**M25 Junction 10/A3 Wisley Interchange
TR010030**

**9.88 Applicant's Comments on Elm
Corner Residents Group Deadline 6
submission**

April 2020

9.88 Applicant's Comments on Elm Corner Residents' Deadline 6 Submission

Project Title:	M25 junction 10/A3 Wisley interchange
Drawing Title:	WISLEY LANE FORWARD VISIBILITY AND CROSS SECTION
Drawing Number:	HE551522 - ATK - HGN - XX
Project Ref. No.:	5158141
Type:	SK - CH - 000034
Volume:	1 of 1
Rev.:	C01

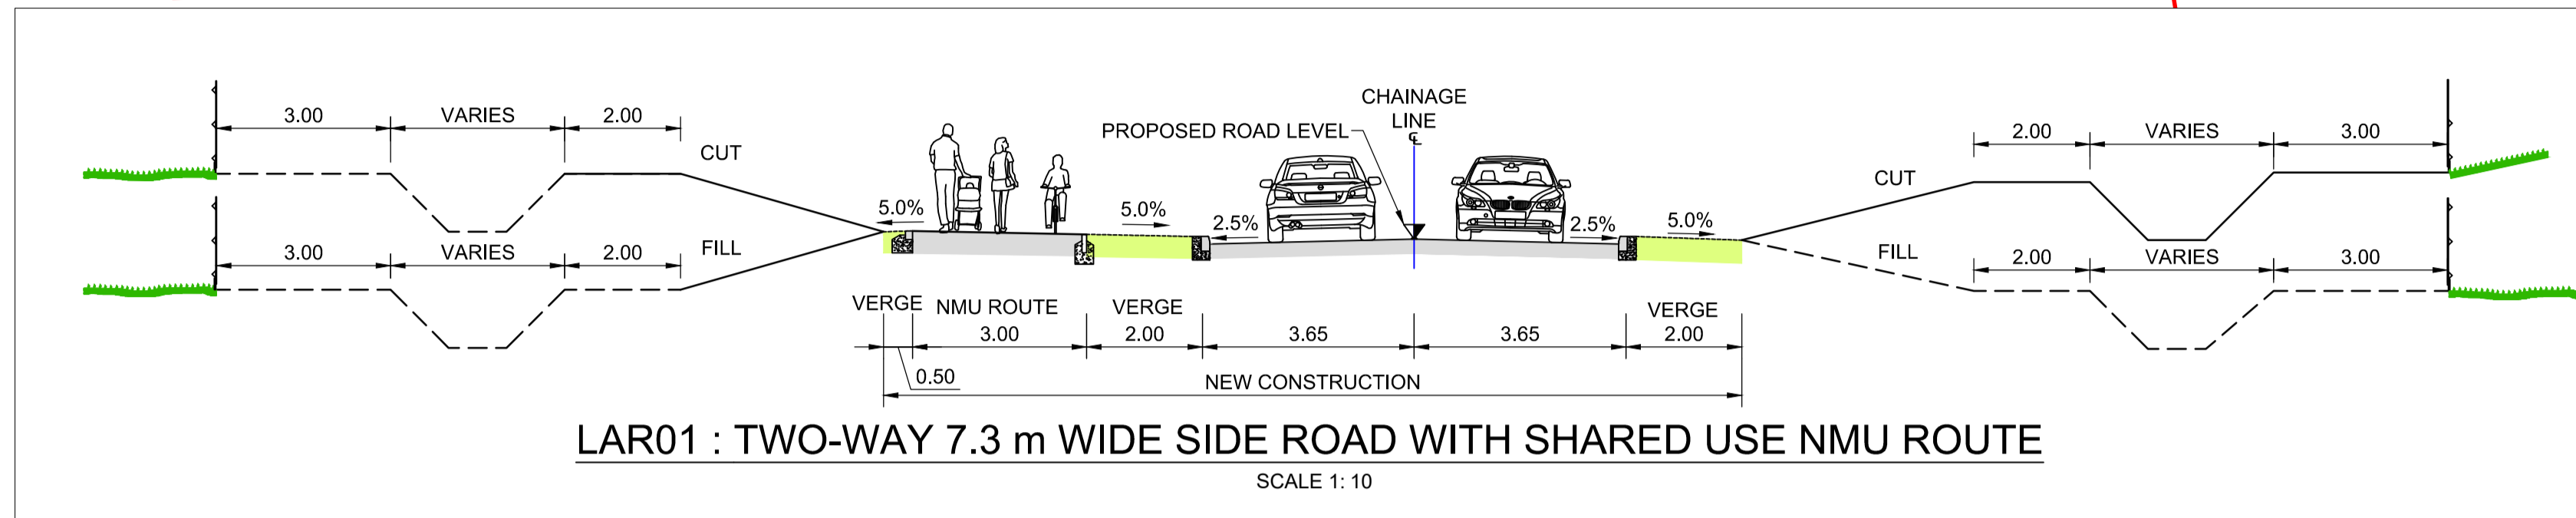
- 2.2.2 With regards to the road safety points raised by Elm Corner Residents Group, the proposed visibility splay and traffic management arrangements set out on drawing HE551522-ATK-HGN-XXSK-CH-000093_C01 (see Appendix A) have been discussed with Surrey County Council as highway authority for this road and agreed as being appropriate for the road type and the levels of traffic predicted in the modelling. Highways England will continue discussions with Surrey County Council on traffic management for detailed design. Highways England does not consider introducing a mini roundabout at this junction is appropriate at this location.
